**Reference:** S12612 / 2019/370679  
10 December 2019

**Ku-ring-gai Council's submission to State Significant Development SSD9912 - Roseville College - 27-29 and 37 Bancroft Avenue, Roseville - proposed new sport and wellbeing centre (SWELL)**

Sheet: EPM05-DA-101

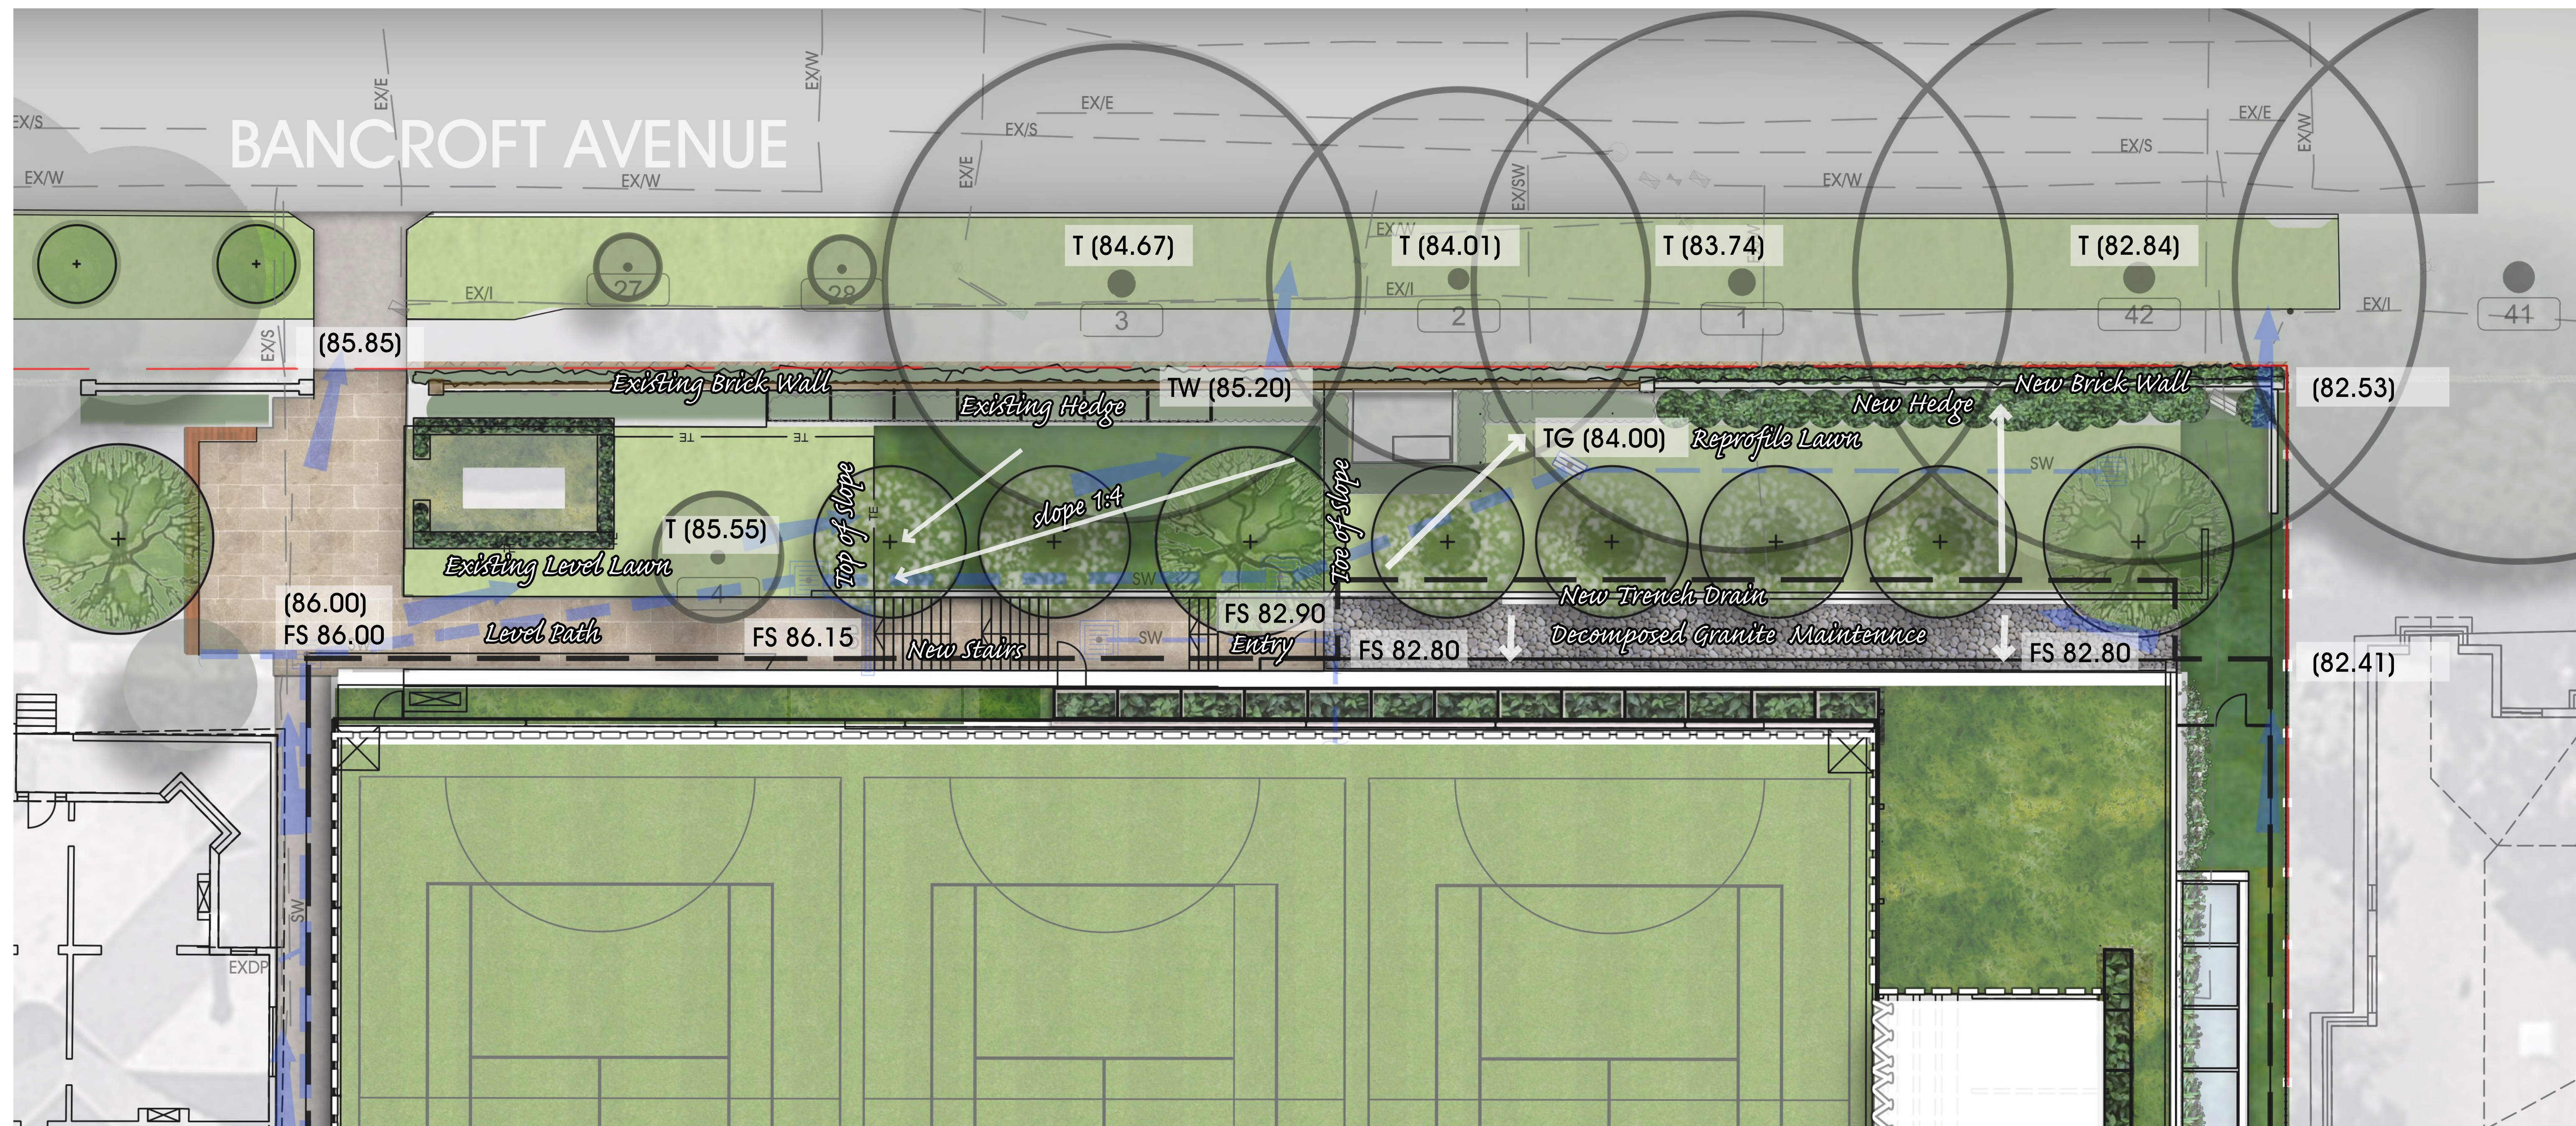
No eastern boundary amenity planting is proposed. The proposal includes 'row' planting of Buxus/Japanese Box, a small evergreen hedging shrub that will not grow above fence height which does not provide screening of the development and therefore does not provide visual amenity to the neighbouring single residential property.

The landscape design proposes replacement planting of 1000Litres *Cedrus deodar* (Himalayan Cedar) to compensate for the removal of Tree 7. While the species is appropriate, the Bancroft Avenue site frontage depth and the proximity of the proposed planting to the building and retaining structures has not considered the species mature dimensions (as evidenced by Tree 7) and therefore the trees would not be viable in the long term. The planting schedule identifies the species growth potential as up to 20m high x 8.0m wide, Tree 7 has dimensions of 18m high x 12.0m wide. Planting of the replenishment trees requires further consideration. An ideal location within the Bancroft Avenue site frontage would be where the substation is currently proposed.

The proposed row planting of 6 x *Pyrus calleryana* (Callery Pear) is inconsistent with the existing desired landscape character. The proposed structured landscape design outcome is inconsistent with the established landscape character. It is recommended the proposed planting be reconfigured to increase tree species variety and to be less formally structured.

Trees to be removed due to development impact.

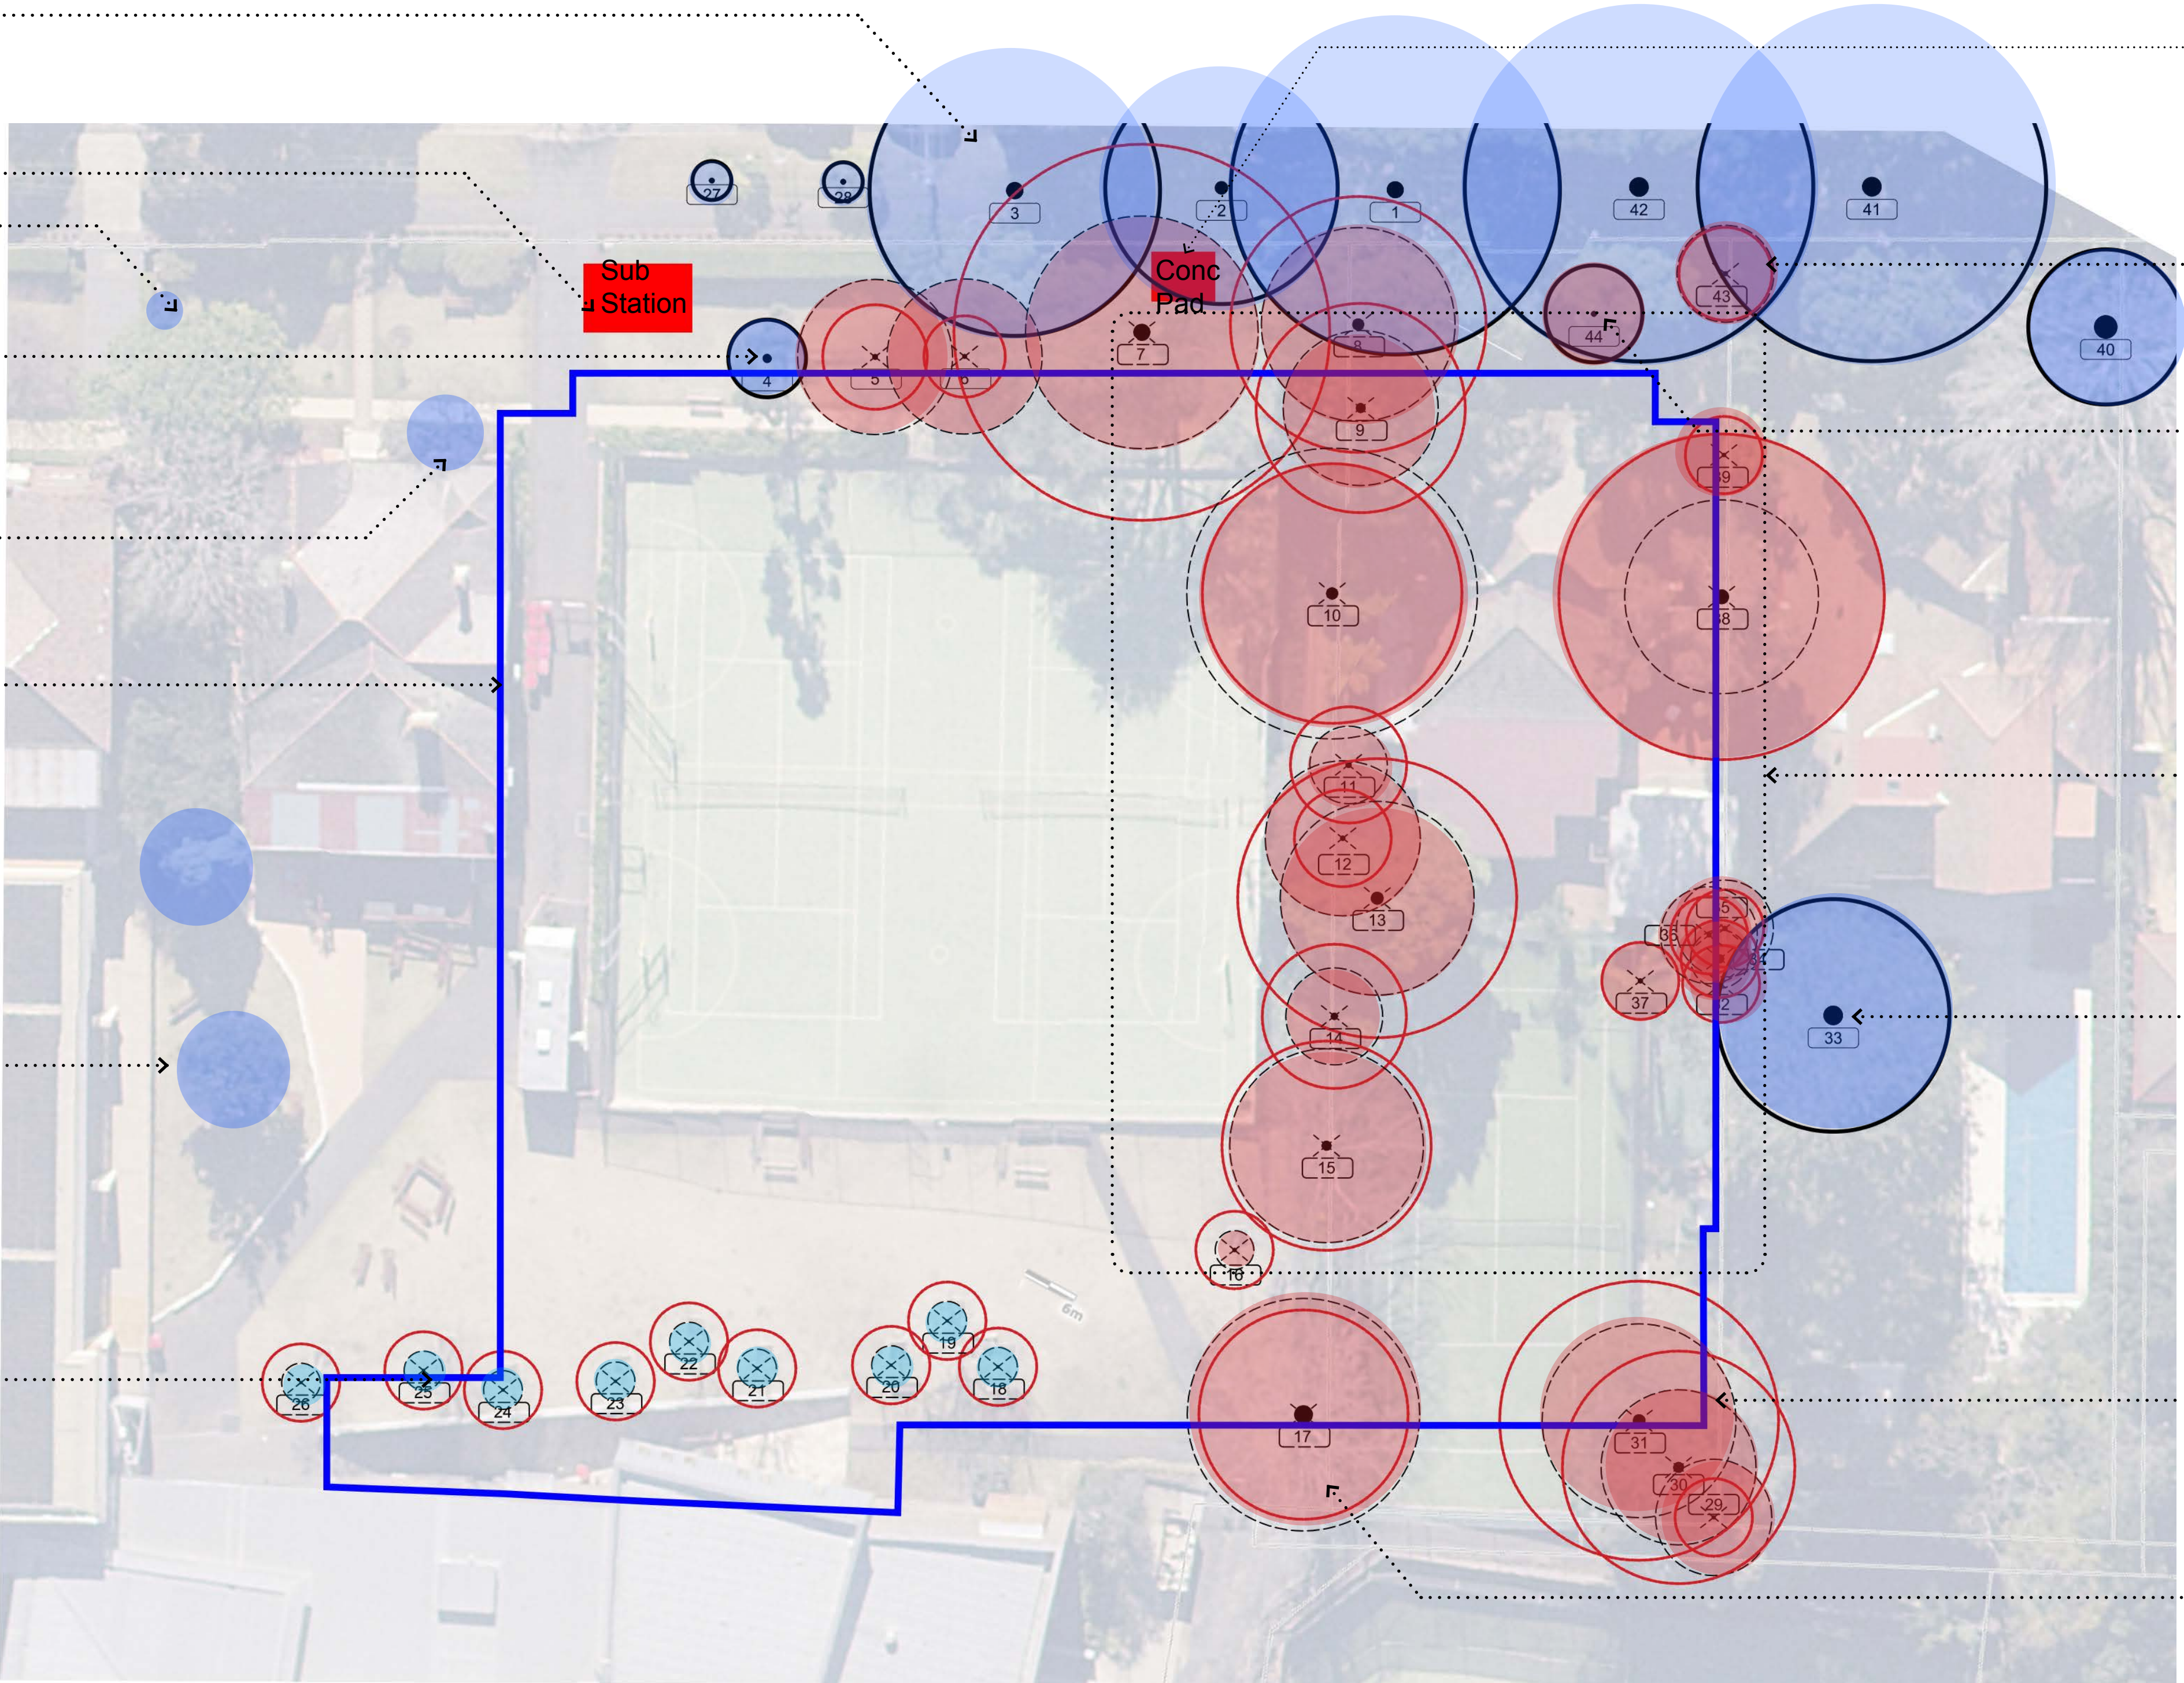
The proposal includes the removal of Tree 7, a mature *Cedrus deodar* (Himalayan Cedar) approximately 18.0m high, with a 12.0m canopy spread, located within the established Bancroft Avenue frontage. The tree is in good health and condition, with terminal spring growth. The tree is identified within the applicant's arborist report as having "*high significance with an 'A' rating – Important trees suitable for retention for more than 10 years and worthy of being a material constraint. The tree has no significant defects and could be retained with minimal remedial care*". Tree 7 contributes positively to the established streetscape character, landscape setting and the HCA.

Council's Senior Landscape Assessment Officer concurs with the applicant's arborist which reaffirms Council's position that Tree 7 is worthy of being a material site constraint and should be retained with suitable development setbacks. There is no arboricultural justification for its removal.
